**Our Case Number:** ABP-316119-23

**Re:** DART+ South West Electrified Heavy Railway Order - Hazelhatch & Celbridge Station to Heuston Station, and Hesuton Station to Glasnevin  
County Dublin and County Kildare

## Planning Observation

**DART+ South West Railway Order - Hazelhatch  
& Celbridge Station to Heuston Station, and  
Heuston Station to Glasnevin**

Project Title	DART + SOUTH WEST	
Drawing Title	EARTHWORKS STANDARD DETAILS SHEET 3	
Drawing File Name	DP-04-23-DWG-RO-TTA-18962	Version v01 Status S3

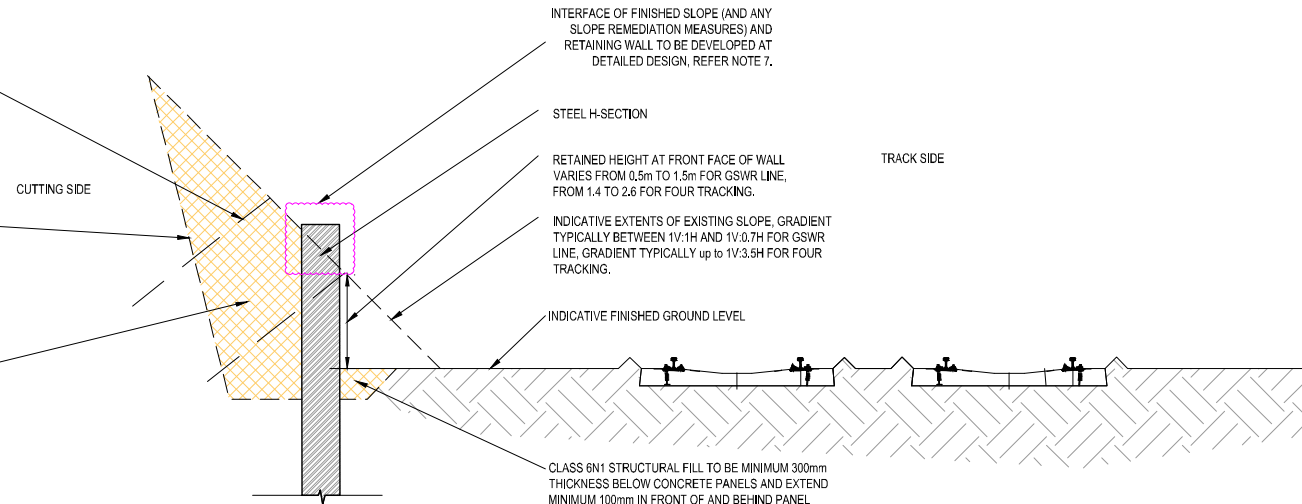
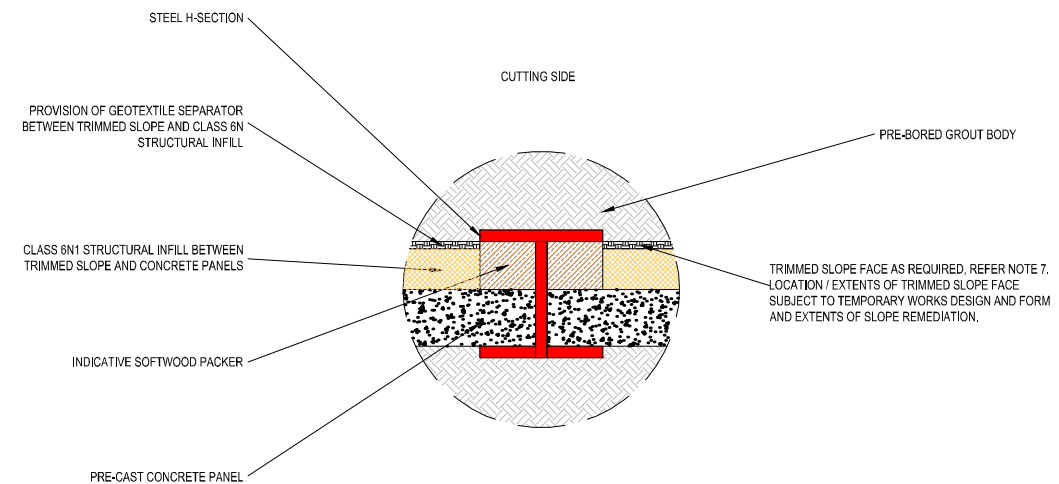
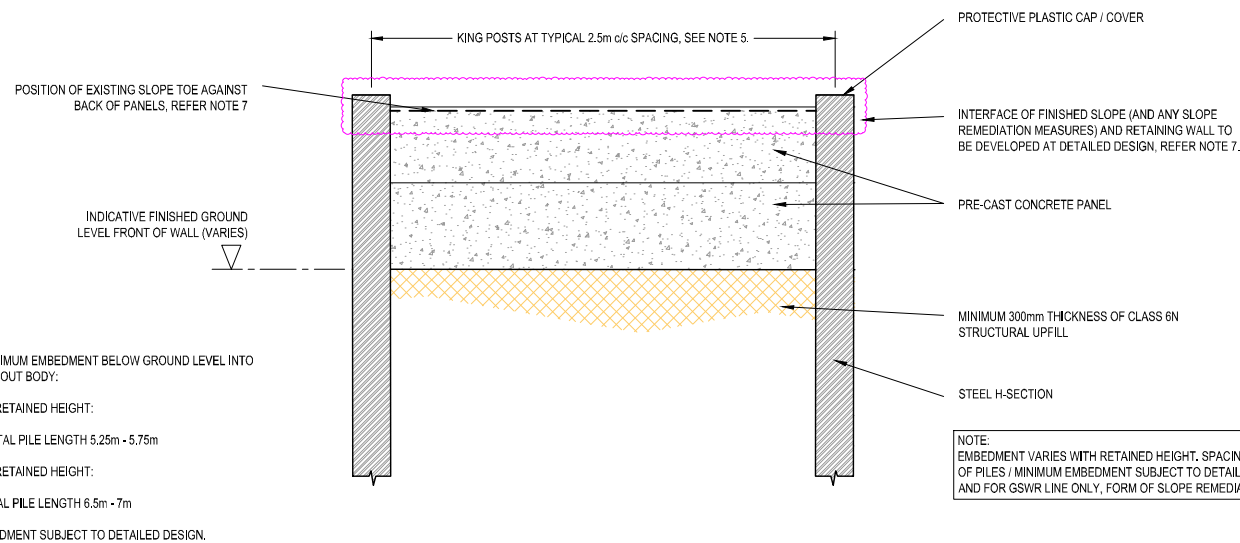
*'Stabilisation of existing railway cutting by means of soil nailing. After clearing the face and top of cuttings of all vegetation; soil nails will be drilled approximately every 1m (vertically and horizontally) using machinery operating from the toe of the cutting (the maximum extent is indicated by the purple shaded area on the Works Layout Plan). This will be done in advance of any retaining wall installation at the toe of cuttings'.*

As acknowledged by the property plans submitted with the railway order, our client's land will be subject to the acquisition of substratum land (DSW.18837.S.411(A)), comprising a c. 0.15 ha strip along the western site of the site. It is not considered that the impact of the proposed soil nails has been thoroughly reviewed with regard to the significant impacts on the future development of the site.

While it is acknowledged that the proposed works are to provide the necessary infrastructure improvements to facilitate the expansion of the DART network, it is at the request of our client that an alternative solution to the proposed soil nails is proposed in order to ensure the protection of the development capacity of the site. It is noted that the detailing for the proposed works has not advanced to date and that during a meeting with Córas Iompair Éireann having taken place on 4<sup>th</sup> May 2023, have agreed that there are other alternative solutions to support the retaining wall.

We note that the use of gabions to act as retaining walls are a viable option for such development and offer an alternative which is significantly less invasive with regard to land acquisition. In addition to this, gabions can be implemented in a shorter timeframe and have high permeability providing for good drainage. It is considered that the use of such is better suited to the referred section of the works required for the DART + expansion, reducing the impact on future development at the subject lands. We refer to the following image included in Figure 17.0 of this submission where gabions have been used to retain the soil along the Glasgow to Edinburgh railway line in Scotland.

It appears that the proposed works represent the worst-case scenario, and due regard has not been had for the impact on our client's site and its development potential, as previously demonstrated by a grant of permission for a student accommodation development under ABP Ref. 300666. The proposed soil nails will significantly reduce the developable lands, therefore impact on the land value.

A generic solution is proposed by CIÉ as opposed to an engineered site-specific solution. We submit there is ample space within the CIÉ lands to deal with the implication of cutting into the toe of the slope without impacting upon this site. It is requested that the railway order application should be conditioned to mitigate the proposed impacts on the subject lands. We would therefore request that An Bord Pleanála consider the impacts of the proposal to ensure that the proposed soil retaining works are revised to provide for such which will have a significantly reduced impact on our client's lands.
